From: Martyn White
Sent: 19 March 2019 11:59
To: Zac Denton
Cc: Planning.Responses
Subject: RE: EP/6/19/PL - Request for additional information

RE: 8 SEA ROAD, BN16 1JP.

ref: EP/6/19/PL.

DETAIL: GARDEN HOUSE
PROPOSED ROOF PLAN

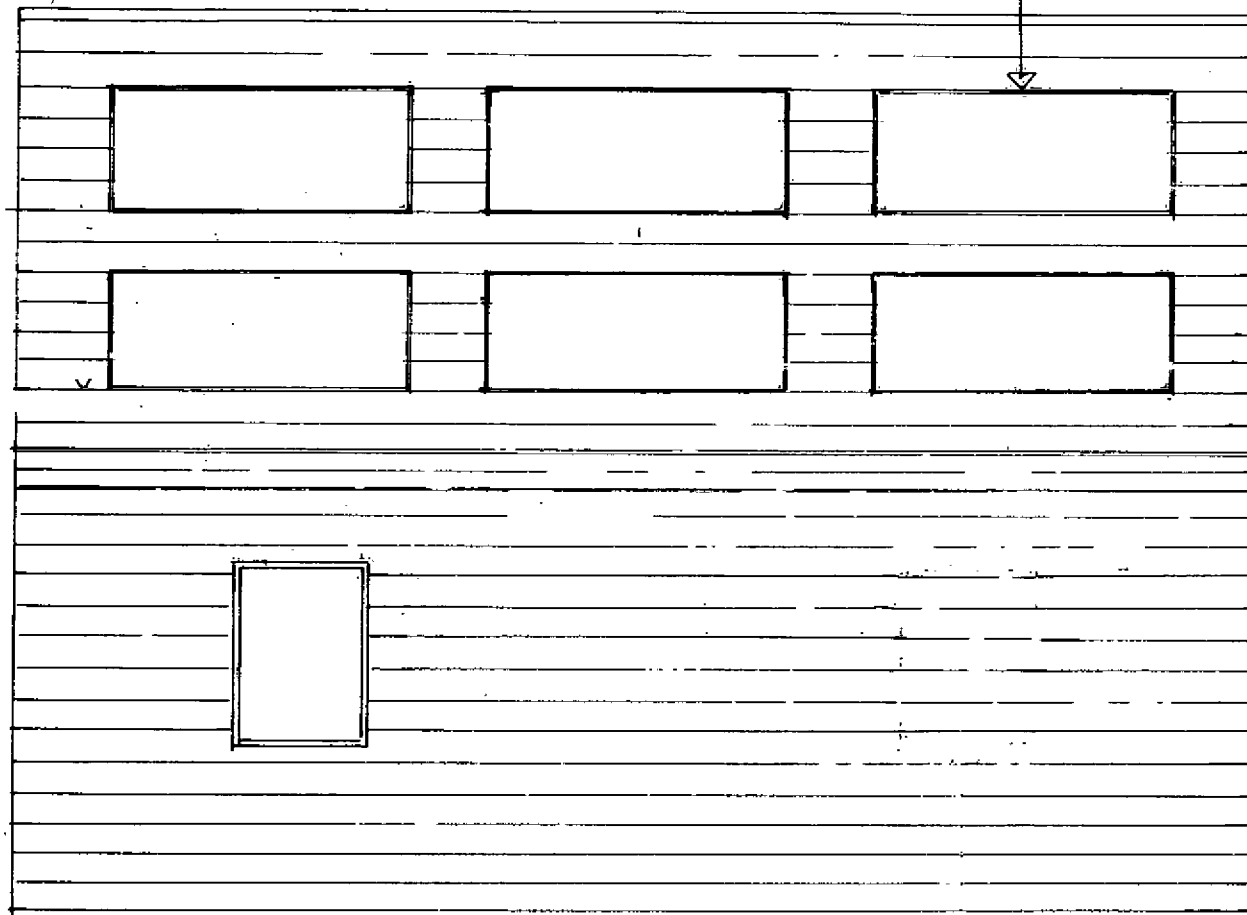
- 2) The proposed solar panels will be partly viewed from the south aspect, however the finish is black & will blend well with the black finish slate roof tiles so shouldn't stand out. The intention is to provide a clean energy supply to both the garden house & cottage.

Thank you for the additional information. I have reviewed the details provided below and can confirm that it is acceptable from a conservation perspective.

MCA INTERIORS
30 Ennismore Avenue London, W4 1SF.
Tel: 07768 743629 Email: mcainteriors@hotmail.com
PROJECT: GARDEN HOUSE SEA RD EAST PRESTON SUSSEX BN16 13P
DETAIL: PROPOSED FLOOR PLAN & ELEVATIONS GARDEN HOUSE
SCALE: 1:50
DRWG. NO: 253/01 (15/10/2018)
AMMDS: REV. A: (30/11/2018)

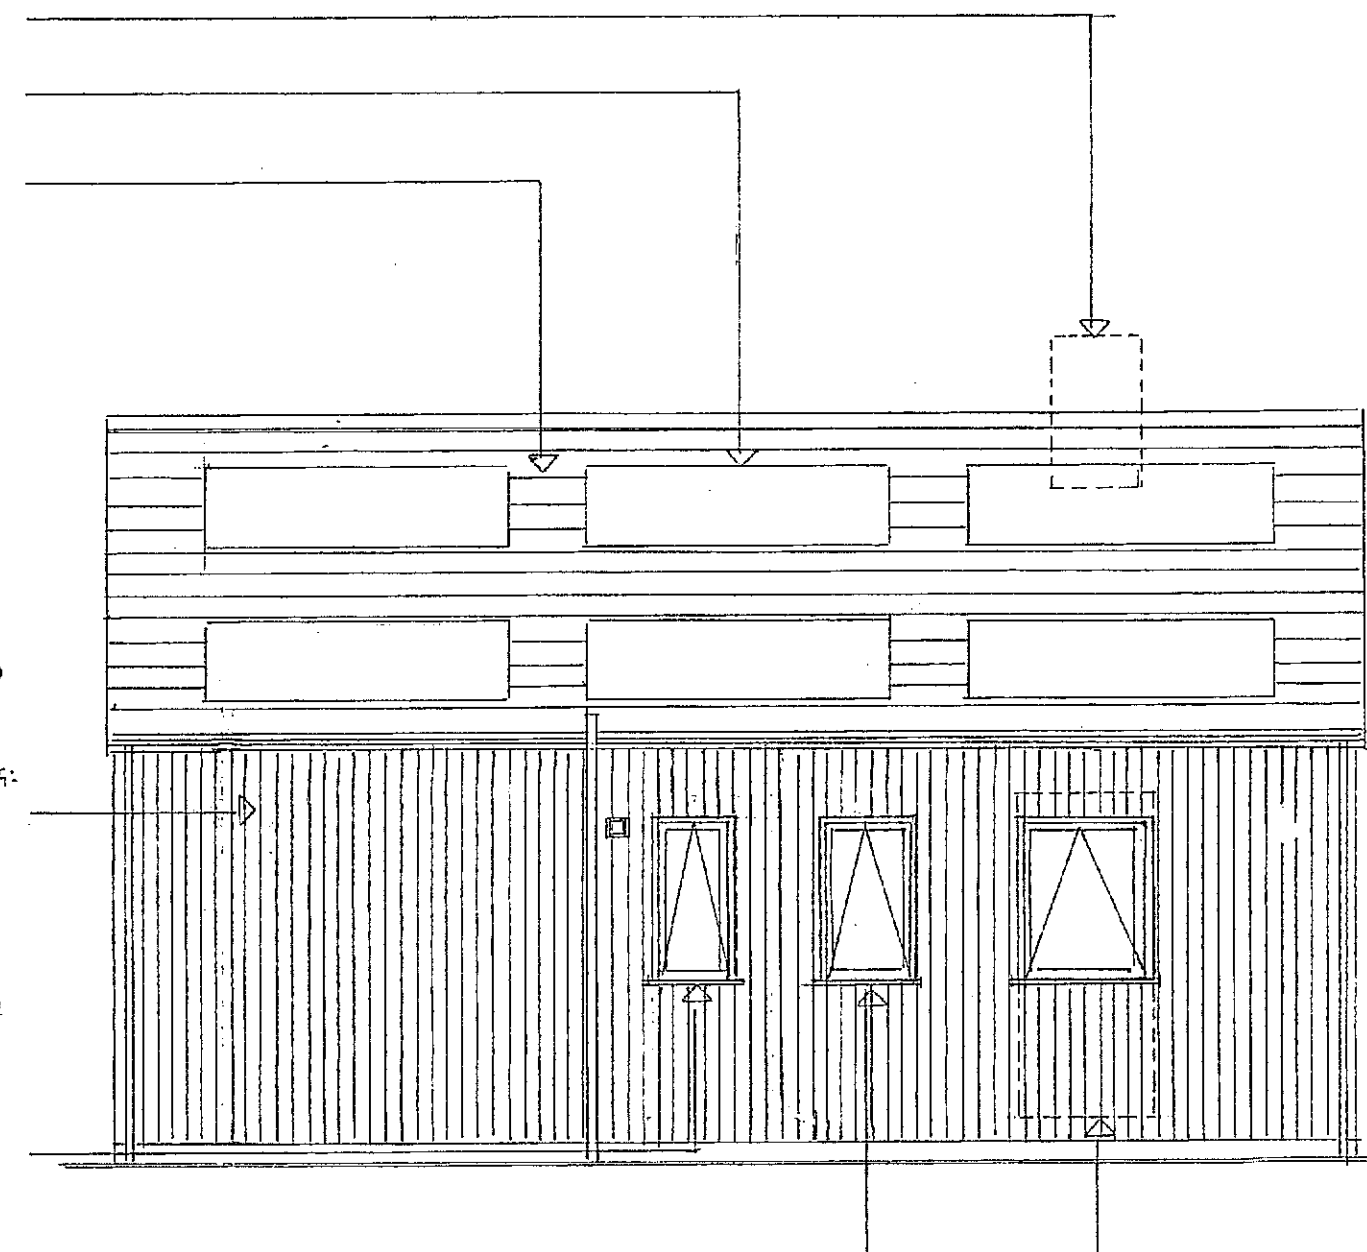
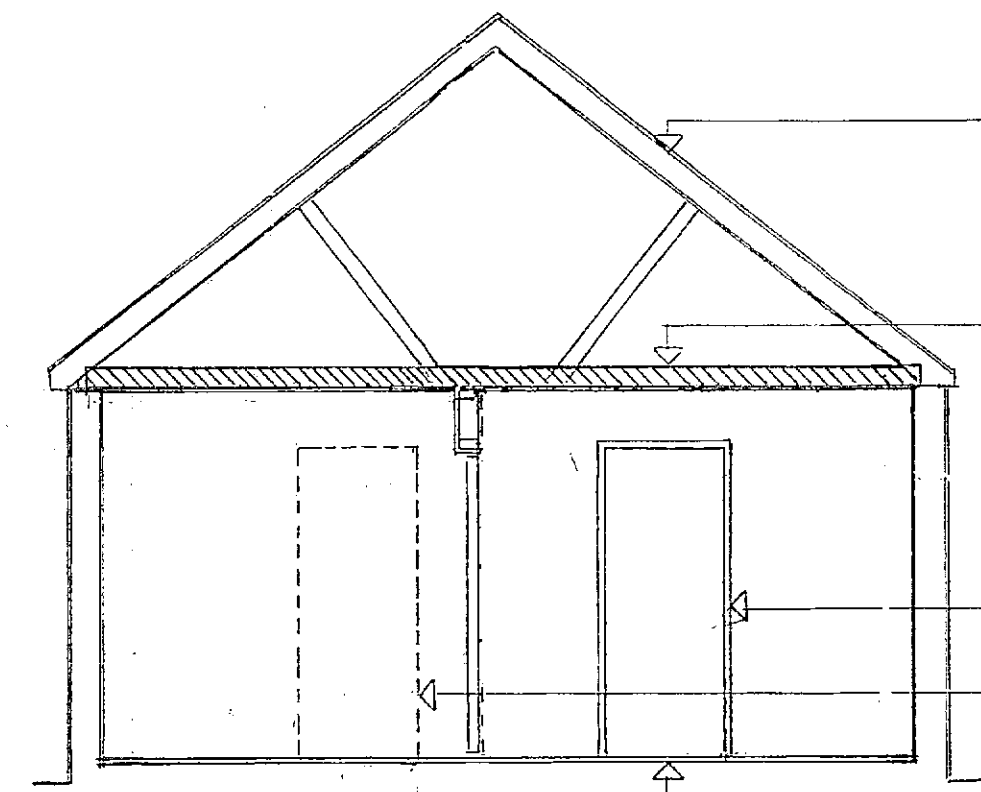
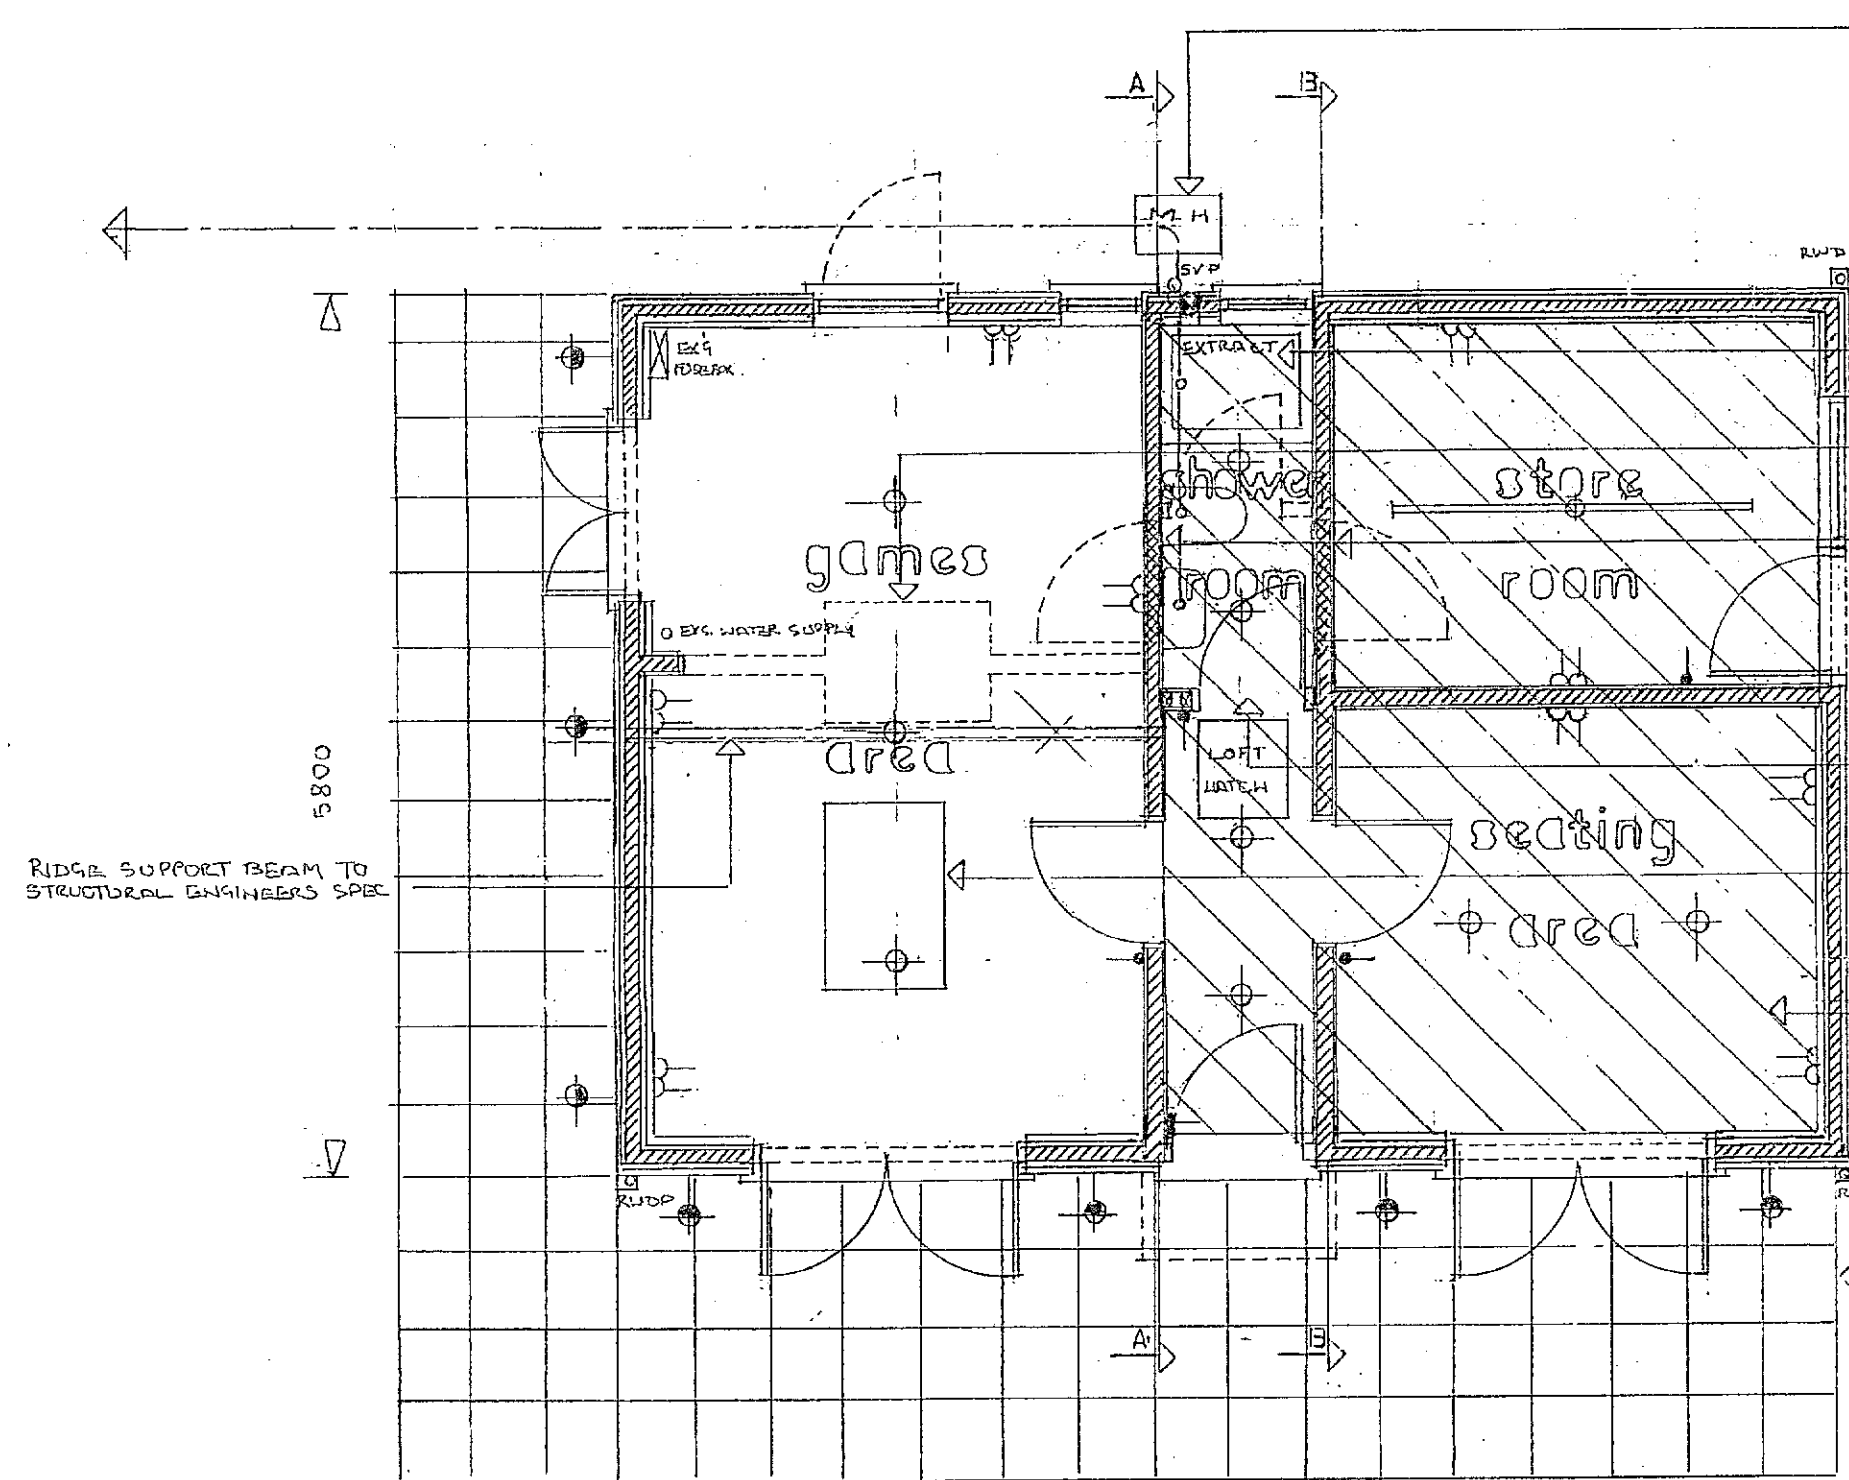
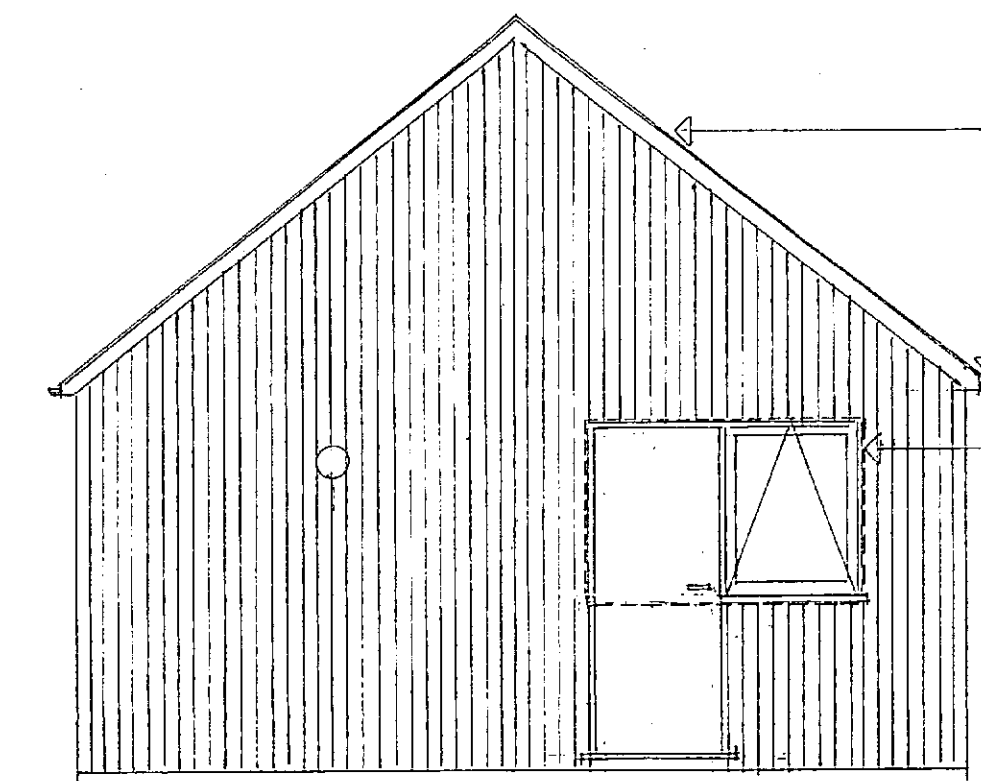
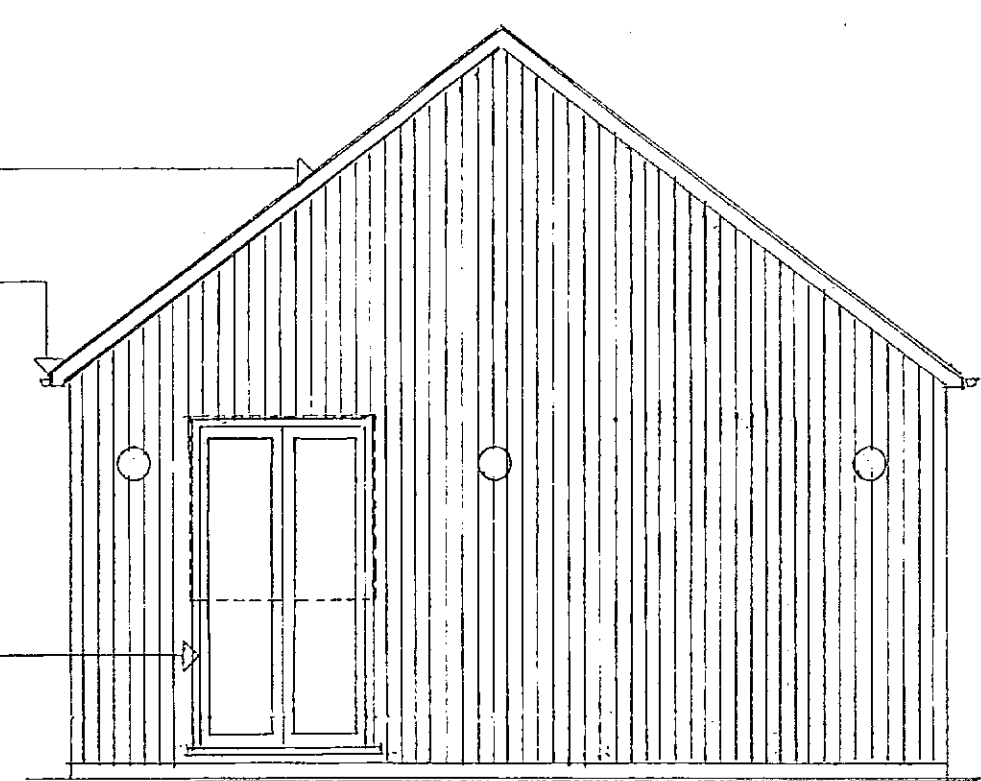
- 1) The Iroko cladding will be untreated & left to weather naturally. It ages well & improves with age. It is used extensively in Canada & Scandinavia as it is hardy.

- 3) The window door spec was not finalised at the time of submission, however this has now been proposed as a dark grey powder coated aluminium framed product by www.slideandfold.co.uk which is highly energy efficient, maintenance free & blends well with the timber cladding. I have attached an image from a recent similar project (although 8 Sea Rd features smaller folding doors within the existing window opening widths to be more commensurate with this building.) I should mention that this combination has been accepted within a world heritage site area. I trust you will agree the combination works well.
